Our ref: AN/2023/134135/01-L01
Your ref: TR030007
Date: 19 April 2023

Planning Act 2008 – Application for Development Consent for the construction and operation of a new three berth Roll-on/Roll-off (“Ro-Ro”) cargo facility in the Port of Immingham, North East Lincolnshire, DN40 2LZ, known as the Immingham Eastern Ro-Ro Terminal (“IERRT”)

- 2.2 We have reviewed the Development Consent Order (DCO) application, Environmental Statement (ES) and supporting documents submitted as part of the above-mentioned application, following notification of its acceptance on 9 March 2023. Our comments are presented using the document references and ES Chapter headings relevant to our remit below.

Figure 4. Bathymetry combined with the Environment Agency LiDAR dataset

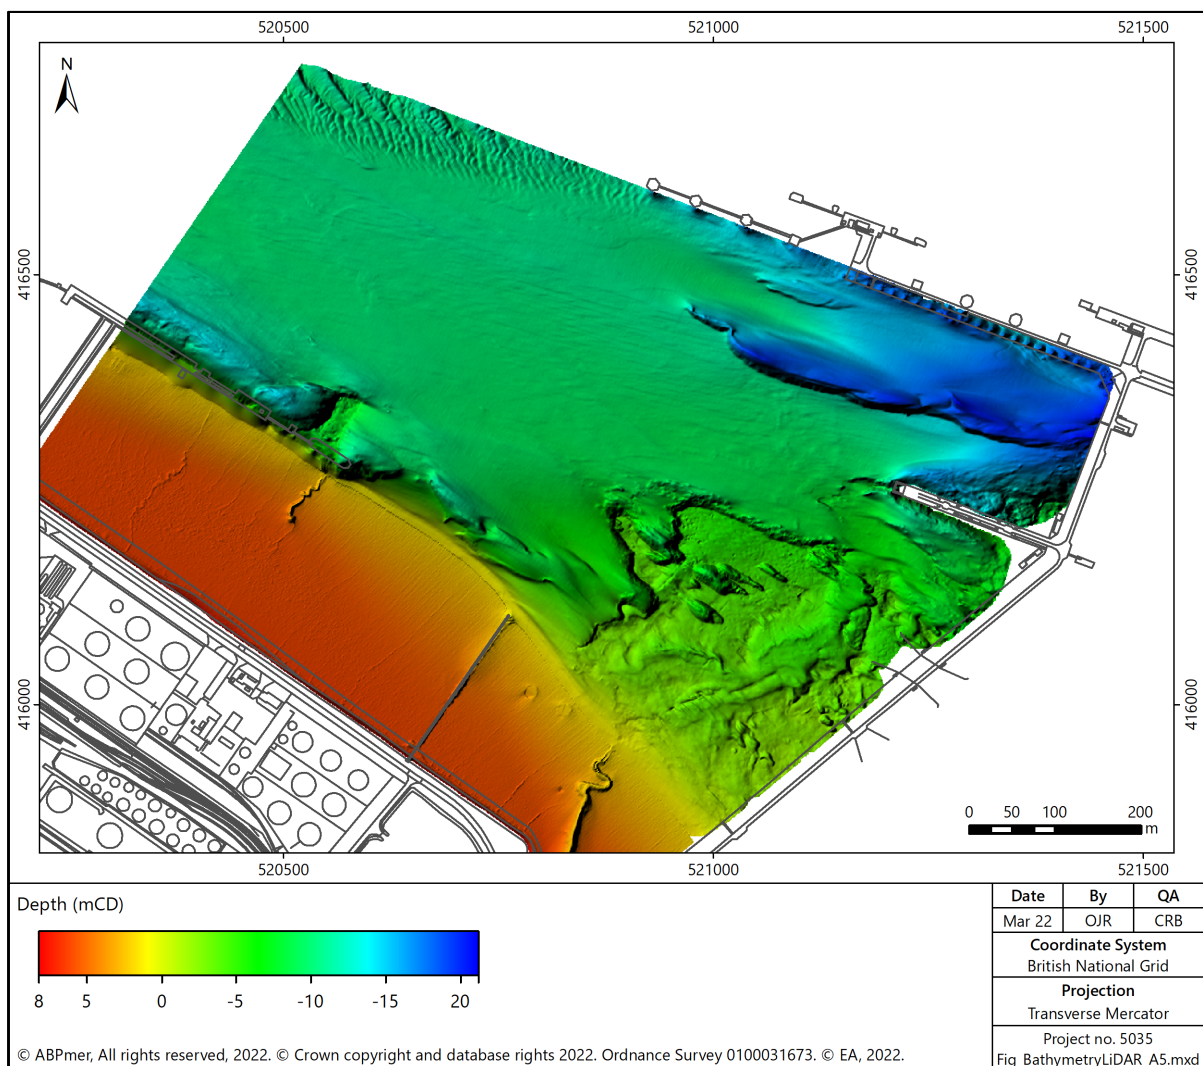
- 4.5 Appendix 7.2 bathymetry plots (Figures 4 & 9): there appears to be an issue with the shading, resulting in inverted topography, i.e. low areas look like they are high areas – the channels look as if they are above the sea-floor as opposed to being incised into it.

Figure 14. Boomer data examples – relevant survey line locations

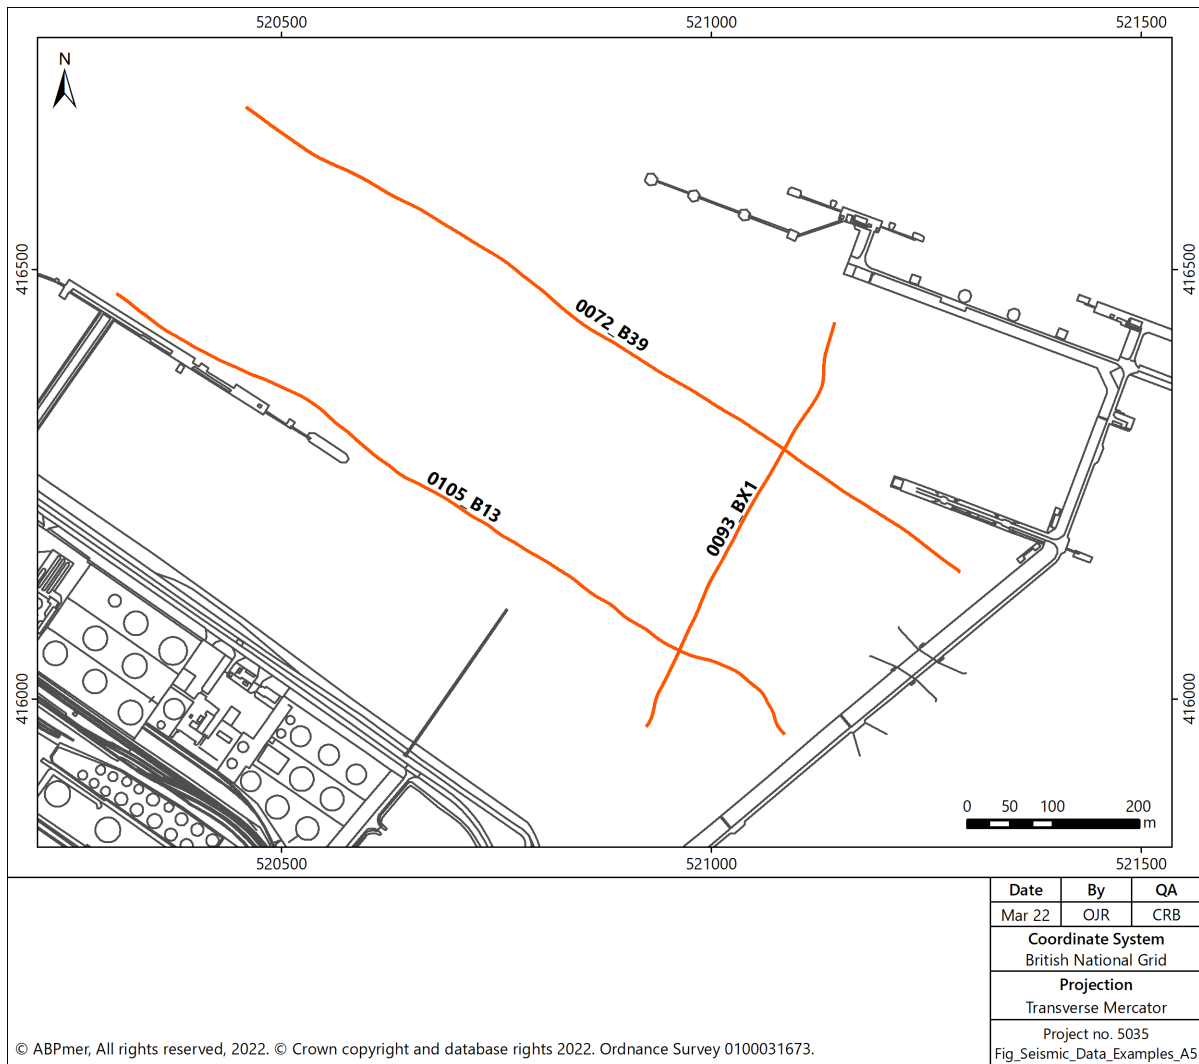
- 4.6 Also, regarding figures in general, not just this report – there appear to be some labelling issues as there are instances where cross sections are labelled, but the associated lines on the map are not; for example, Figure 14 - map and Figures 15-17 – cross sections. Scale bars and place names to allow easy identification of features and assist with orientation are also missing from some of the figures.
